City of Albuquerque Stormwater Construction Site Inspection Report

General Information					
ESC File No.	B11E013	Project Name:	Apartments on Buglo		
NPDES Id. No.	NMR1003YA	Location:	5530 Buglo Ave. NW		
6/14/2021		Owner	Contractor		
Operator		Sharif Rabadi Trustee of Star Trust			
Contact name & title		Sharif Rabadi		Mohamad Tahat	
e-mail		startrustofnm@yahoo.com		mntahat10@gmail.com	
Contact Phone #		505-440-6443			
COA Inspector		Thomas Evans		Start/End Time:	10:00 AM-10:20 AM
Construction Phase:		idle/temporary stabilization			
Type of Inspection:		<input type="checkbox"/> Storm Event	<input type="checkbox"/> Past Storm Event >0.25"	<input type="checkbox"/> 311/Complaint	<input checked="" type="checkbox"/> Follow Up
Weather at time of inspection?		clear		Temperature: ~	85
Estimated date of last storm 0.25" or greater		5/31/2021

From: Evans, Thomas C.
To: ["startrustofnm@yahoo.com"](mailto:startrustofnm@yahoo.com); ["mntahat10@gmail.com"](mailto:mntahat10@gmail.com)
Cc: [Hughes, James D.](#)
Subject: Apartments on Buglo - 5530 Buglo Ave. NW; Permit # NMR1003YA; ESC # B11E013
Date: Wednesday, June 16, 2021 1:39:00 PM
Attachments: [image001.jpg](#)
[B11E013 21.06.14.21F_Inspecti

TEMPORARY EROSION AND SEDIMENT CONTROL PLAN

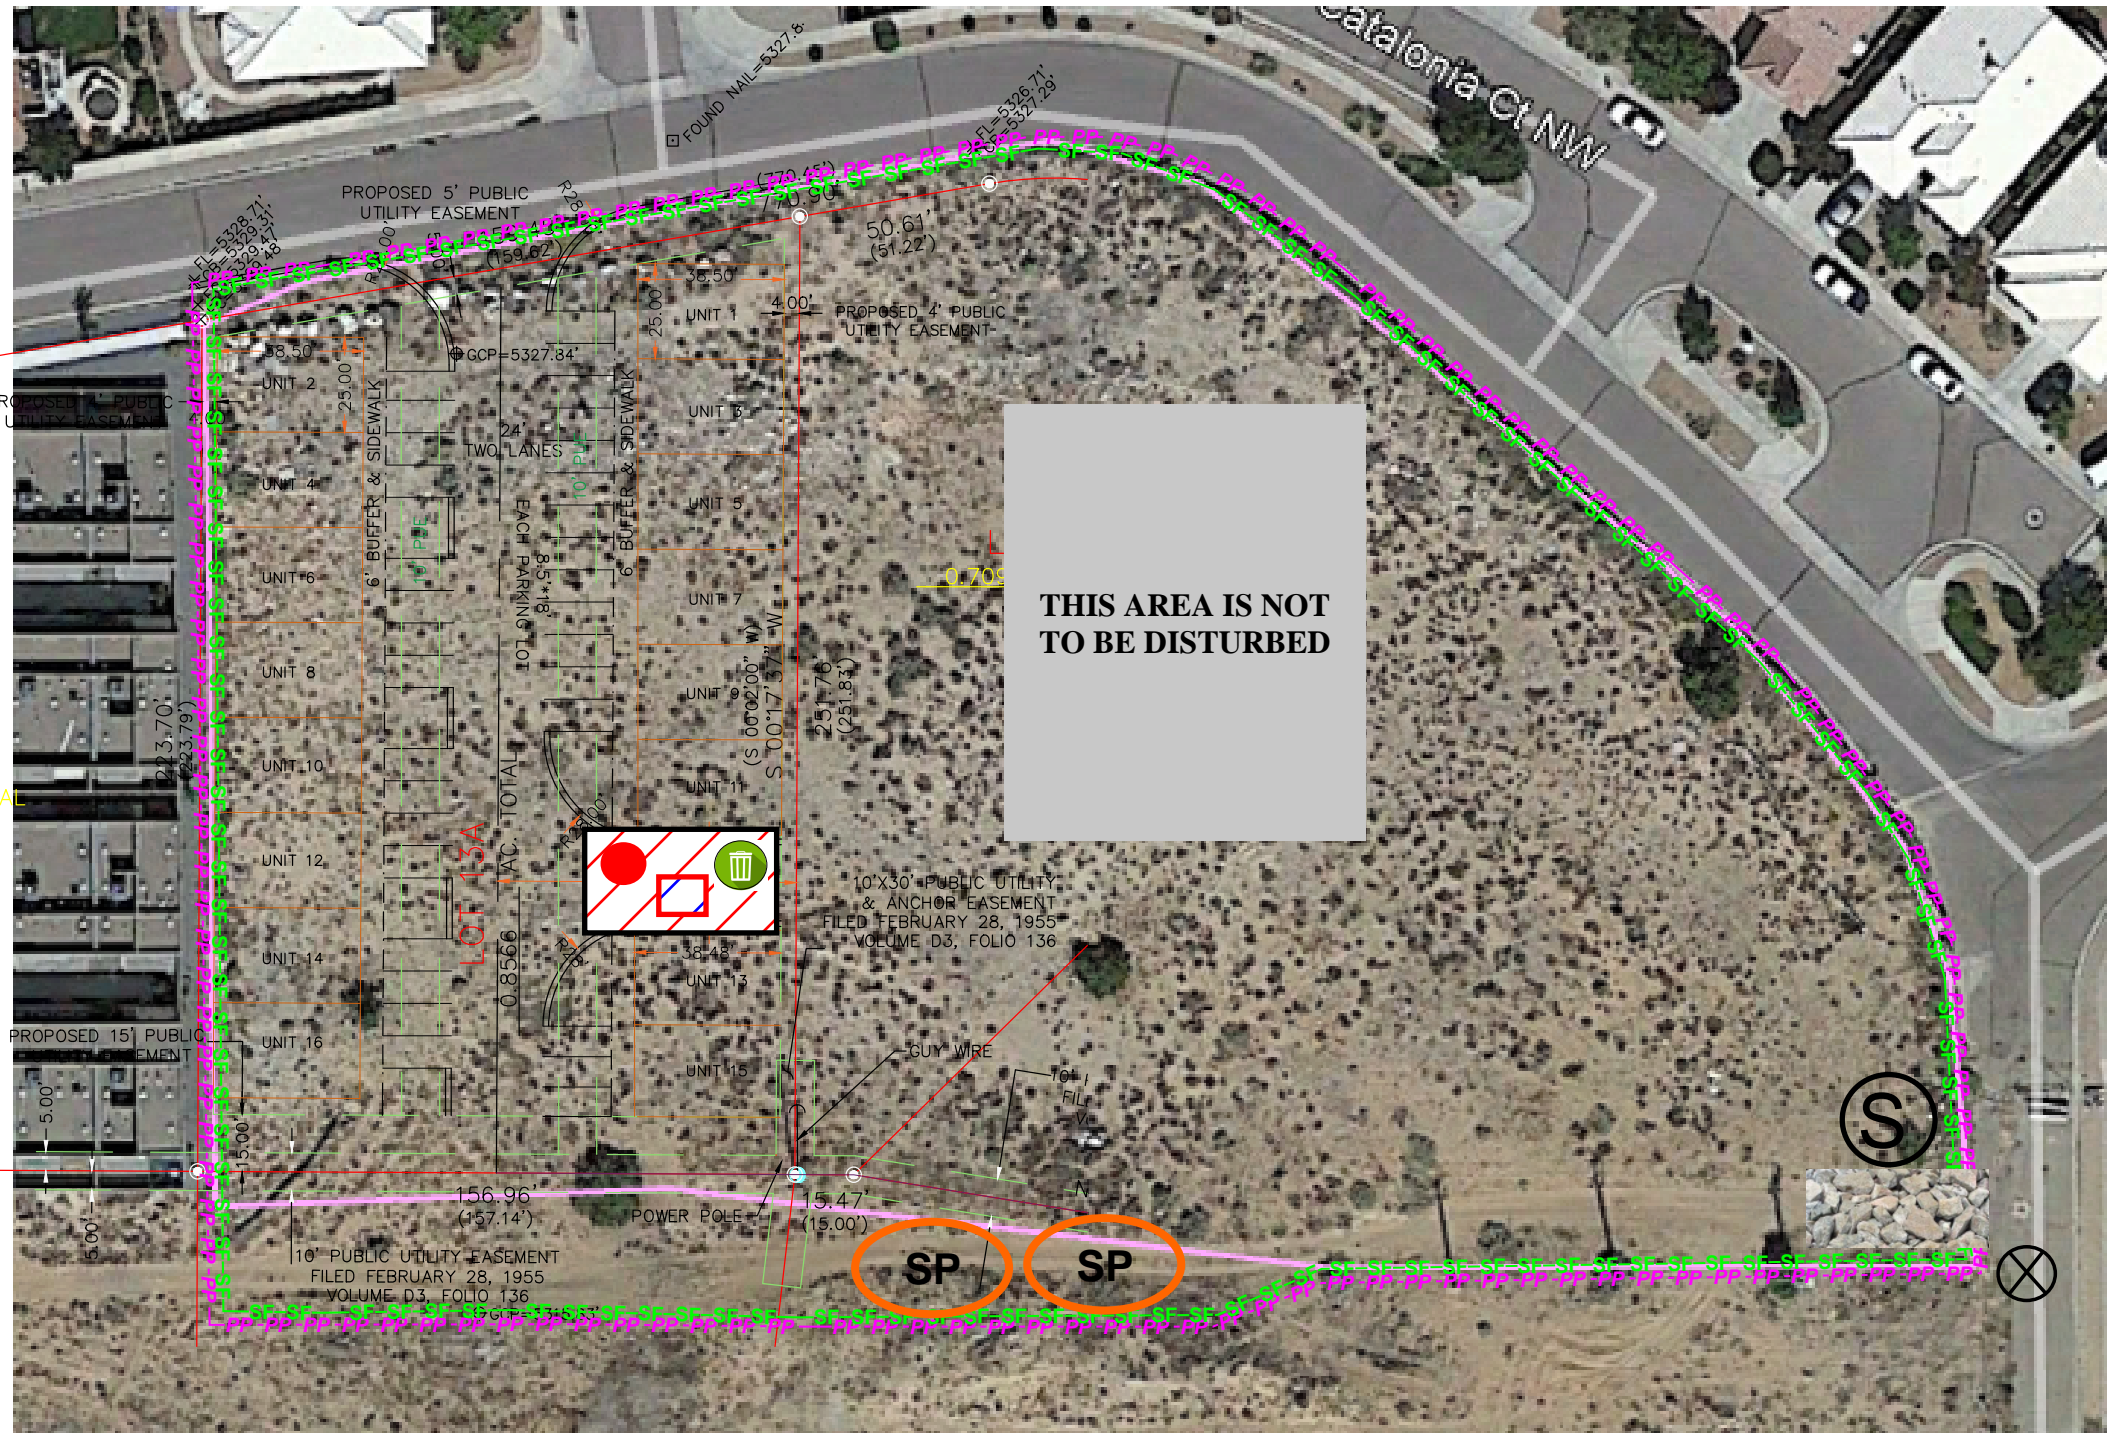
1. The hydromulch on the West half of the site (flat areas) has deteriorated and its condition should be monitored on the upcoming self-inspection reports.
2. The strip of land South of the site will act as a buffer. This needs to be noted on the site map and in the ESC Plan. Please provide copies when completed.
3. Upon moving the pile of dirt, a sediment trap was created at the SE corner. This needs to be noted on the site map and in the ESC Plan as well.
4. A formal submittal of the updated map is required for approval prior to obtaining a building permit.
